DELEGATED DECISION

Planning permission is sought for the Erection of a 2-bedroom, 3-person dwelling with private amenity space , refuse area and car parking. Erection of a single storey rear extension to the original house.

46227/APP/2016/4601 54 BEECHWOOD AVENUE HAYES

01 - GROUND FLOOR PLAN

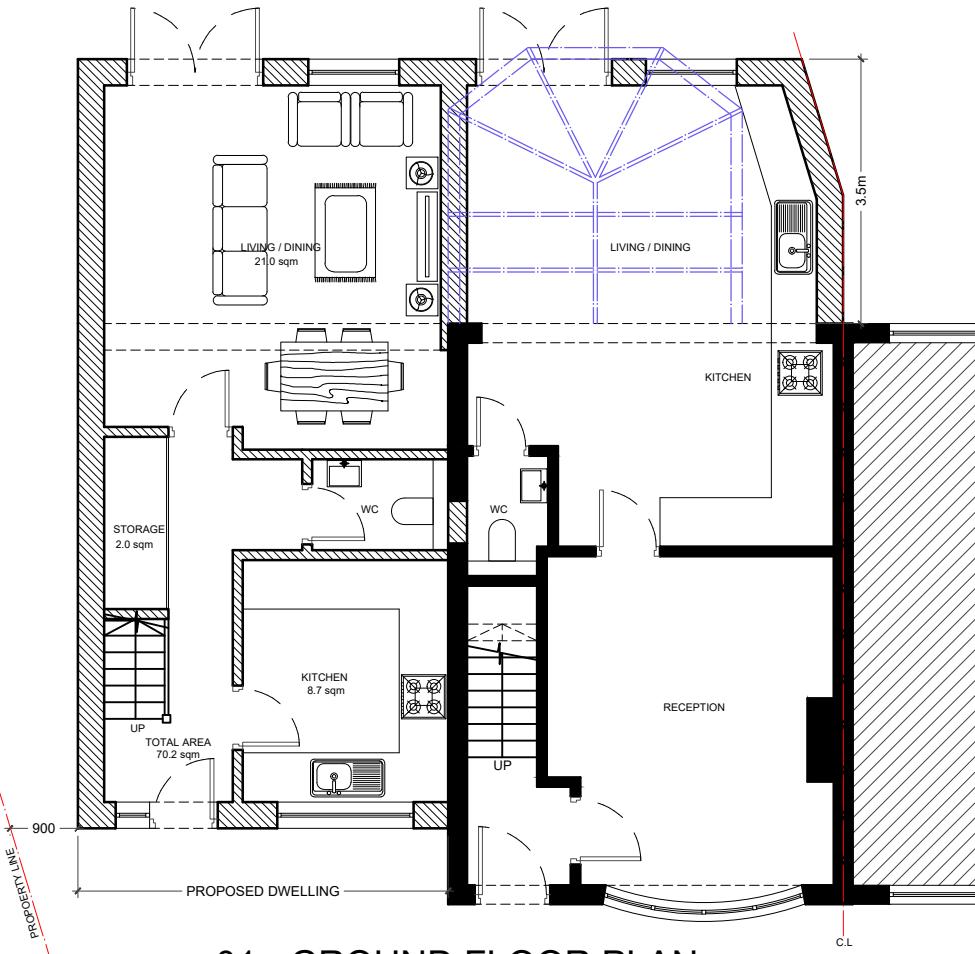
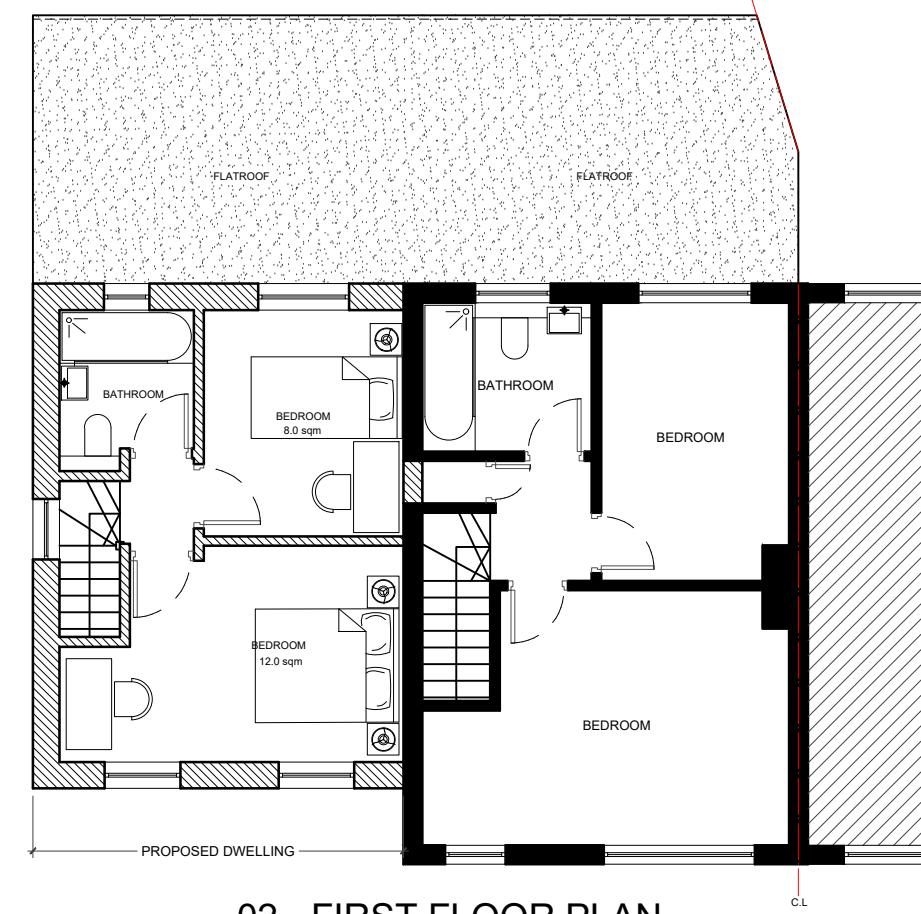
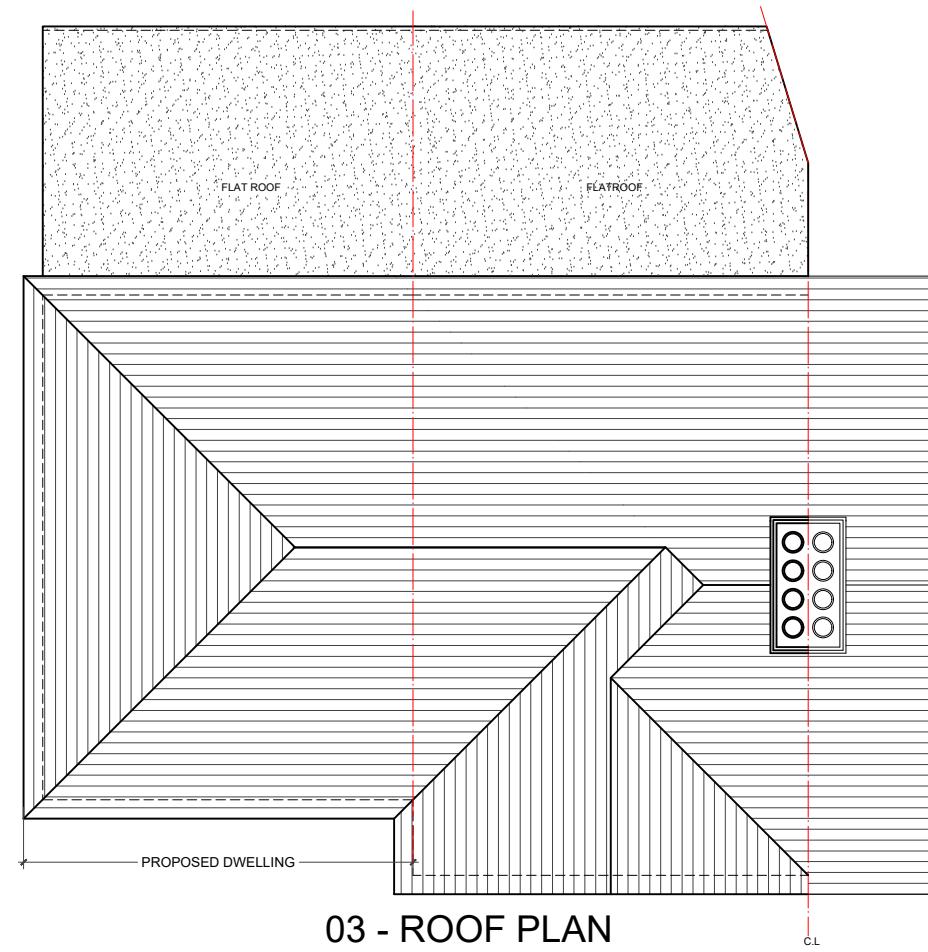
The proposed new dwelling would measure 4.9m in width, 10.1m in depth at ground floor level, 6.6m in depth at first floor level, be set back from the front elevation of No.54 by 1m, set in from the side boundary by 0.9m and would be set down from the main ridge height of the row of terraces characterised with a pitched roof. The proposed dwelling would infill the spacious gap to the side of the property which is an important feature within the street scene. Both No.54 and 58 Beechwood Avenue (corner plot properties) are characterised with spacious plots and it is considered that the infilling of this space would create a cramped appearance out of character with the surrounding area. In addition to this, the new dwelling would significantly breach the front building line of Ash Grove to a harmful degree and at two storeys in height would be readily visible from multiple public vantage points. Whilst the site does benefit from a large side plot, it is not considered that the erection of a new dwelling in this location is appropriate for its setting and would cause harm to the character and appearance of the surrounding area.

01 -PROPOSED SITE PLAN

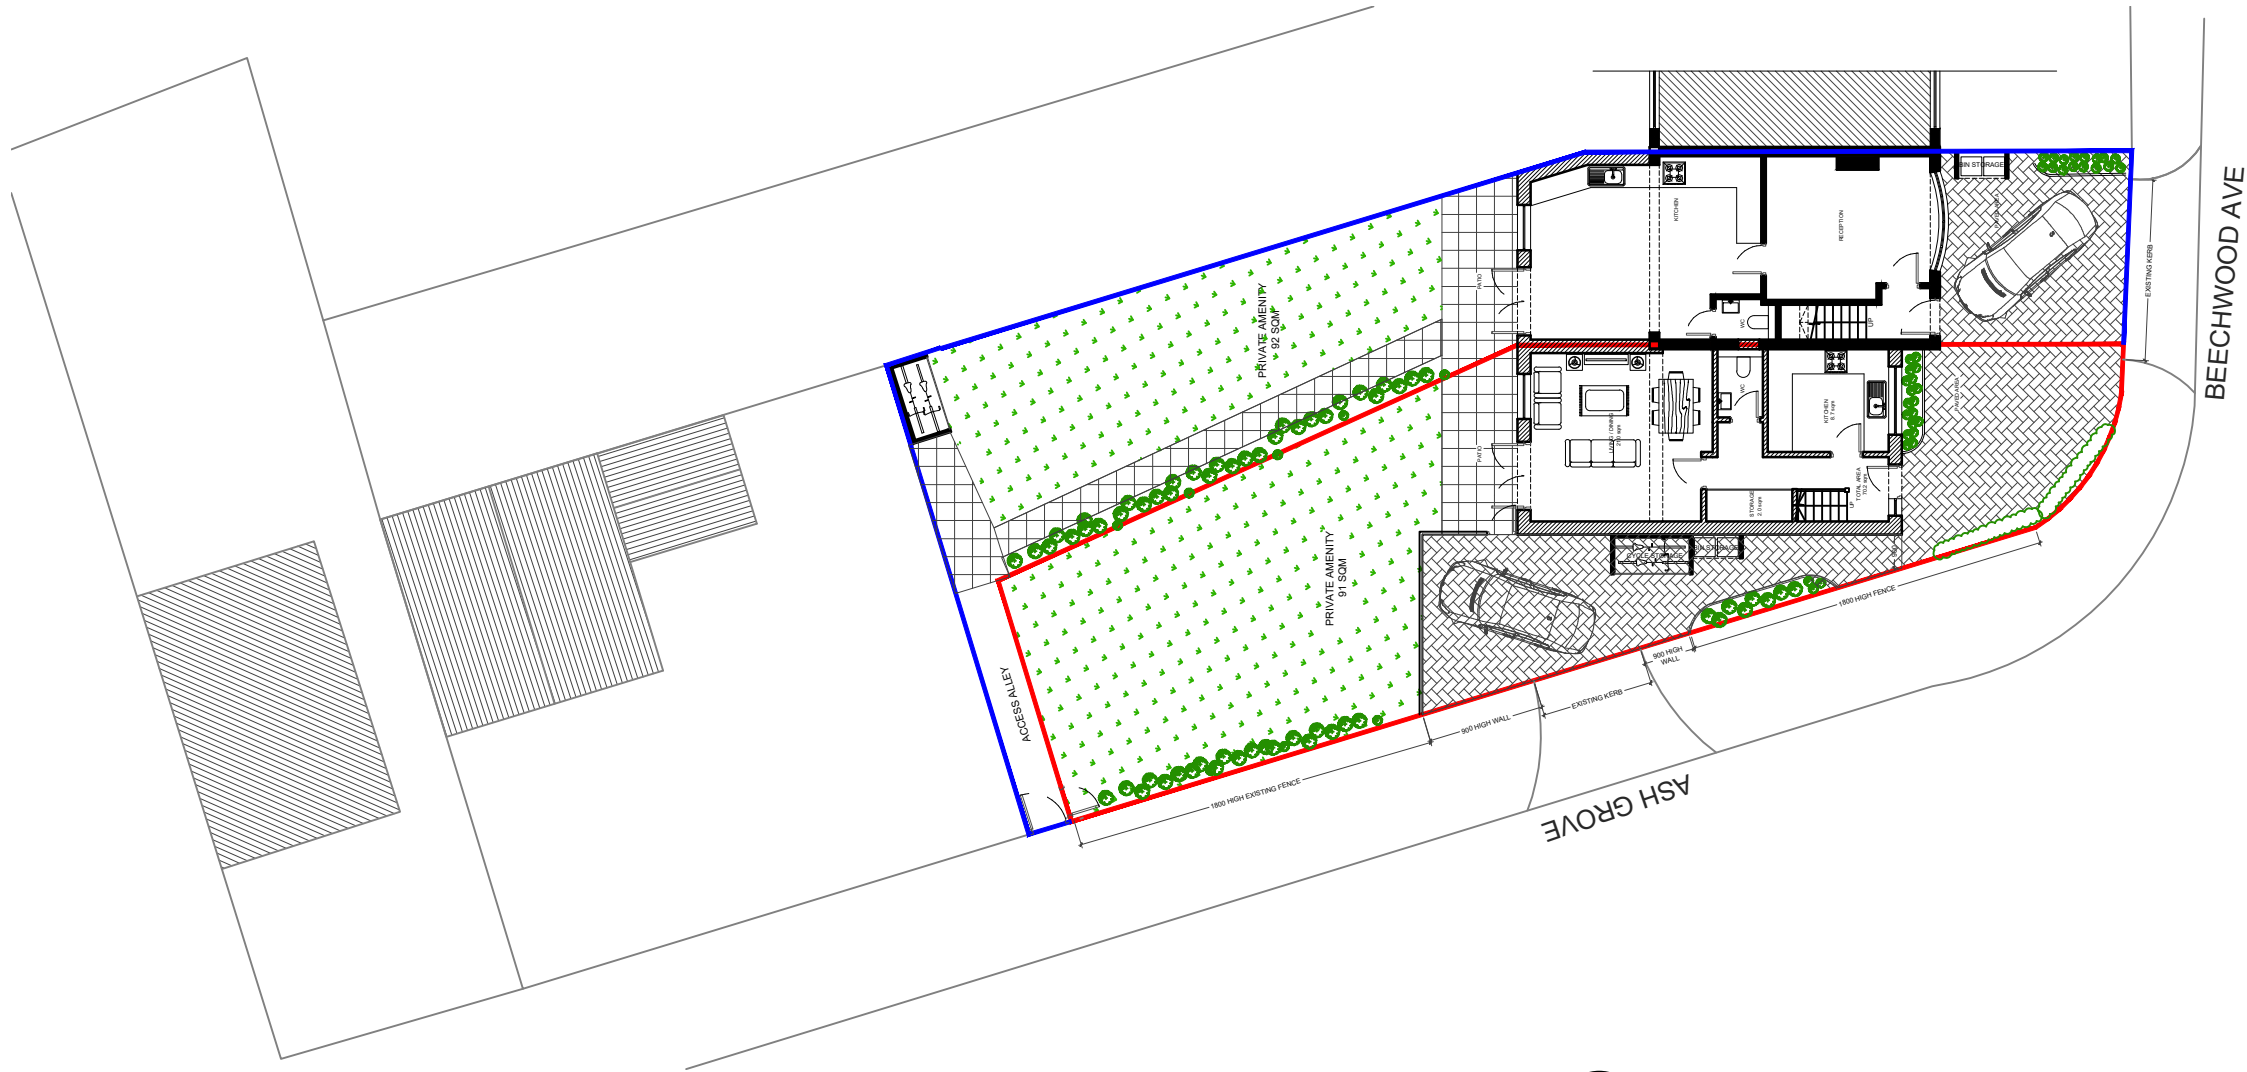
The proposed new dwelling parking bay is at an angle to the public highway including the proposed car parking layout for the donor dwelling both car parking arrangements are not acceptable. Such parking arrangements due to the angles and manoeuvres involved would require drivers to awkwardly and uncomfortably turn their head/neck to the extreme end in order to see in both directions for pedestrians and vehicles, drivers are likely to manoeuvre quickly, potentially without due care to avoid physical discomfort, thereby creating potentially hazardous conditions for all road users. This would be exacerbated further by the none provision of pedestrian visibility splays and its proximity to the adjacent junction adding to potential conflict points. Guidance requires that a vehicle hardstanding should be at least 4.8 metres deep and set out at perpendicular to the public highway (see link below).

The applicant did not provide annotated dimensions of the cycle parking storage and layout on the submitted plans to demonstrate that the dimensions and access widths are compliant with Local Plan Part 2 DMT5, the London Plan or London Cycling Design Standards. From the drawings submitted it would be impractical/difficult to access the bike stores with ease and therefore would discourage cycle use and travel.

The proposed new dwelling parking bay is at an angle to the public highway including the proposed car parking layout for the donor dwelling both car parking arrangements are not acceptable. Such parking arrangements due to the angles and manoeuvres involved would require drivers to awkwardly and uncomfortably turn their head/neck to the extreme end in order to see in both directions for pedestrians and vehicles, drivers are likely to manoeuvre quickly, potentially without due care to avoid physical discomfort, thereby creating potentially hazardous conditions for all road users. This would be exacerbated further by the none provision of pedestrian visibility splays and its proximity to the adjacent junction adding to potential conflict points. Guidance requires that a vehicle hardstanding should be at least 4.8 metres deep and set out at perpendicular to the public highway. Guidance also requires the provision of pedestrian visibility splays, measuring 2.4m by 2.4m, these should be provided. The fences, walls and shrubs within these areas to be kept to a maximum height of 0.6m. In addition to this, vehicular splays should be provided in accordance with national recommendations, specifically Manual for Streets.

The proposed drawings show the provision of cycle storage for 2 bikes to the side of the new property and cycle storage within the rear garden for the existing property accessed via Ash Grove. Should the application have been recommended for approval, a condition would have been secured to provide further details of this storage.
